**Addendum No. 1**

RE: Contract ID: C202313

**Durham County (R-5135, Etc.)**

**June 16, 2009 Letting**

MANHOLE ADJUSTMENTS IN PAVED STREETS

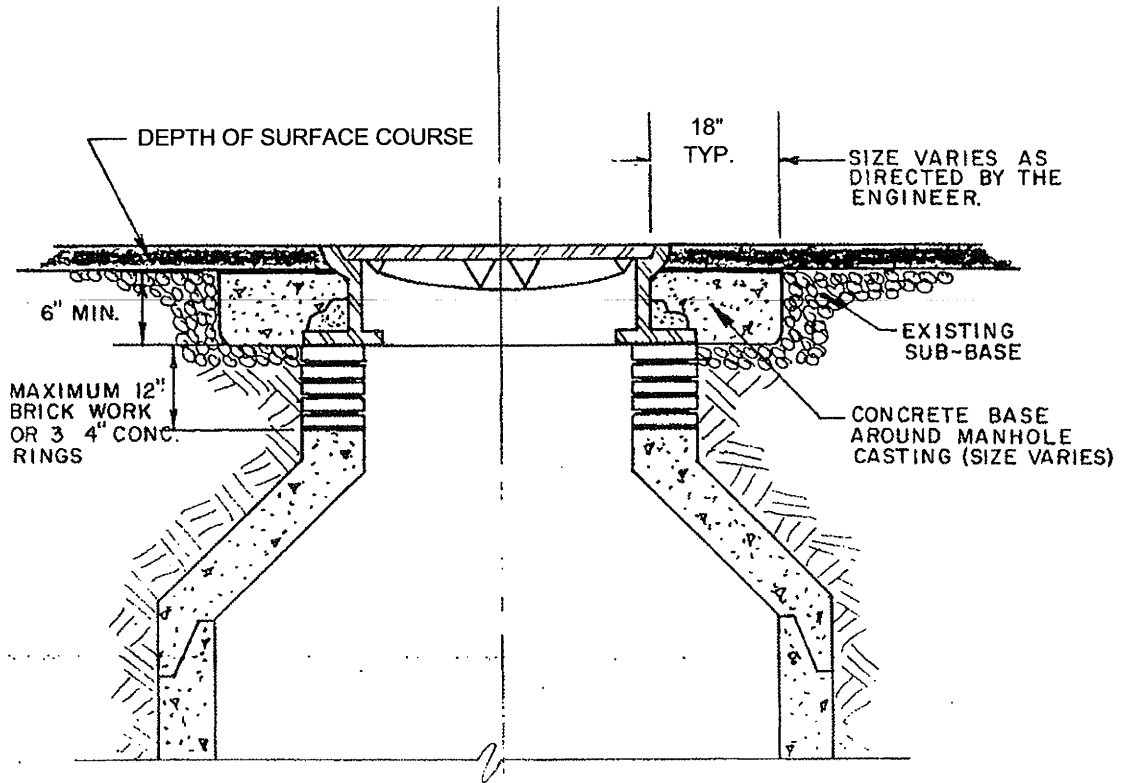
On New Page No. 42-A, the project special provision entitled "Adjustment Of Manholes and Water Valves (City of Durham)" has been added. Also, New Page Nos. 42-B and 42-C have been added to include the City of Durham details for manhole and valve box adjustments. Please staple New Page Nos. 42-A, 42-B and 42-C after Page No. 42 in your proposal.
